WEST SUSSEX COUNTY COUNCIL CONSULTATION

TO:	Arun District Council FAO: K Welch
FROM:	WSCC - Highways Authority
DATE:	30 July 2021
LOCATION:	8 Beagle Drive Ford BN18 0NY
SUBJECT:	F/11/21/PL Installation of a prefabricated concrete workshop at rear of properties garden with rear access onto Lewis Lane and retrospective application for the historical realignment of the rear boundary fence. This application is in CIL Zone 2 (zero rated) as other development.
DATE OF SITE VISIT:	n/a
RECOMMENDATION:	More Information
S106 CONTRIBUTION TOTAL:	n/a

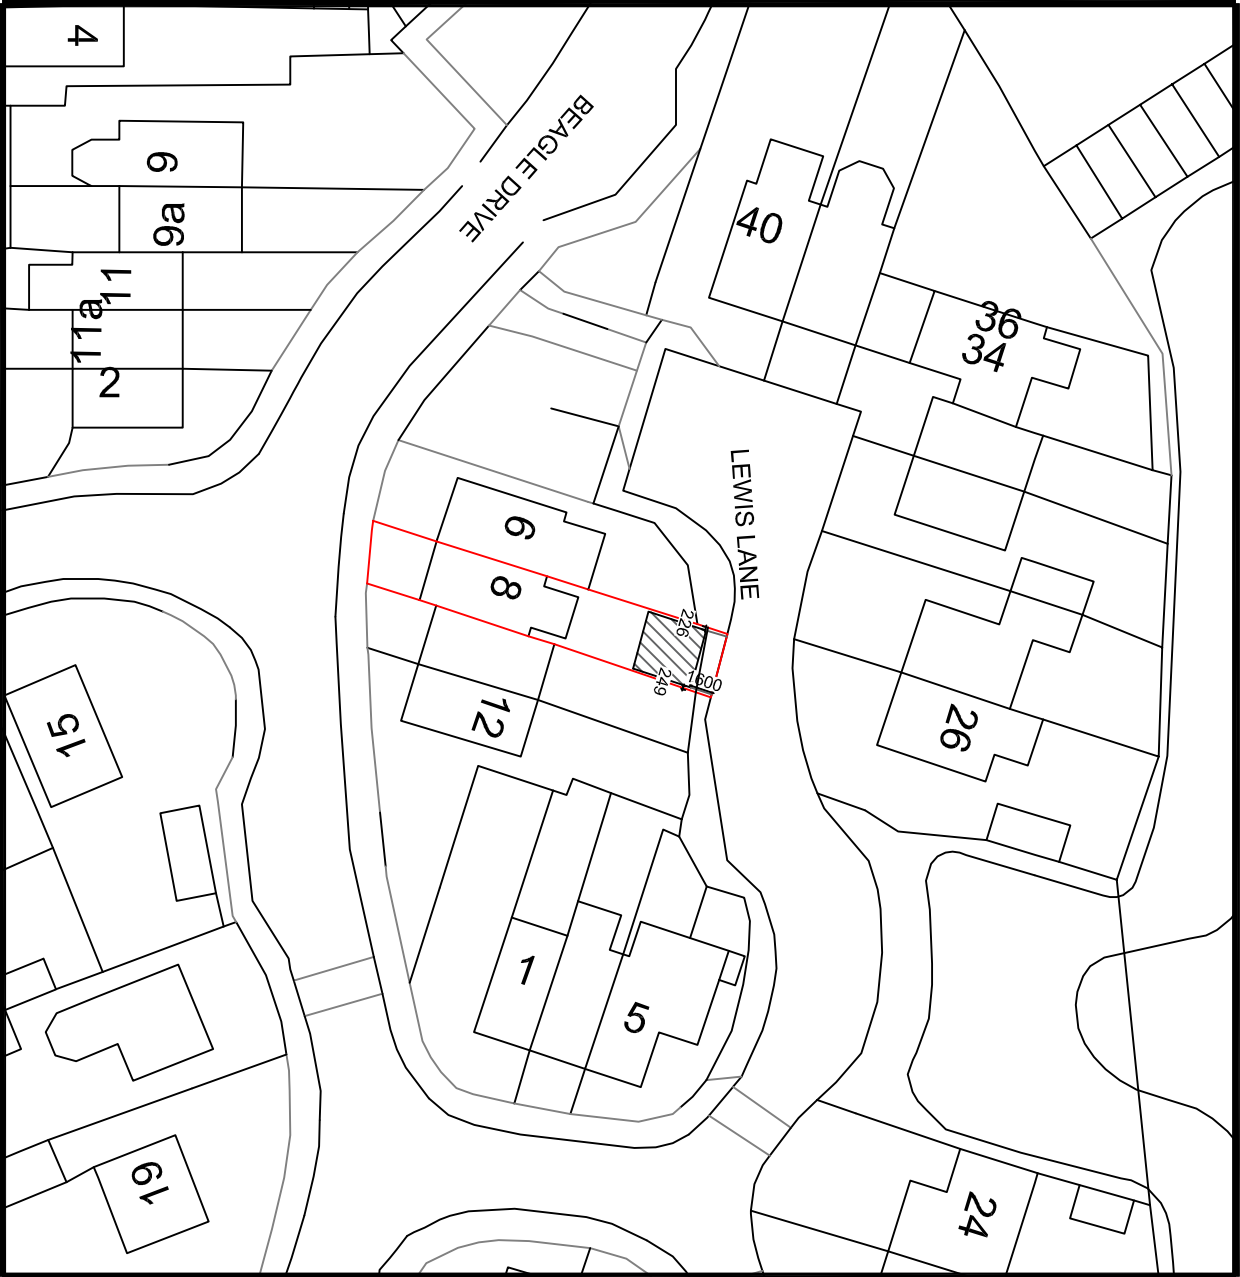
No details appear to have been submitted in regards to the proposed historical realignment of the rear boundary fence. The applicant is requested to provide a plan demonstrating the existing and proposed fence position for the LHA to assess.

The application form indicates that there is no new access to be provided onto the public highway, however, also lists a concrete hard-standing/vehicle access within the Materials section. From inspection of the Block Plan, it does appear that the hard-standing may have been constructed across land considered to be public highway and appears to be intended to provide vehicular access to the site. Any works within the public highway are subject to a licence from the WSCC Area Engineer and must be constructed to their specification, including dropping the kerb. Any works within the public highway that have not been granted a licence are subject to enforcement action by WSCC as Local Highway Authority.

The applicant is requested to provide a plan demonstrating clearly the extent of the hard-standing area and if vehicular access to the site is intended, a plan should be provided demonstrating the proposed dropped kerb. The applicant should be aware that if the hard-standing has been erected within the public highway and no vehicular access is intended, the hard-standing will be required to be removed and the verge re-instated.
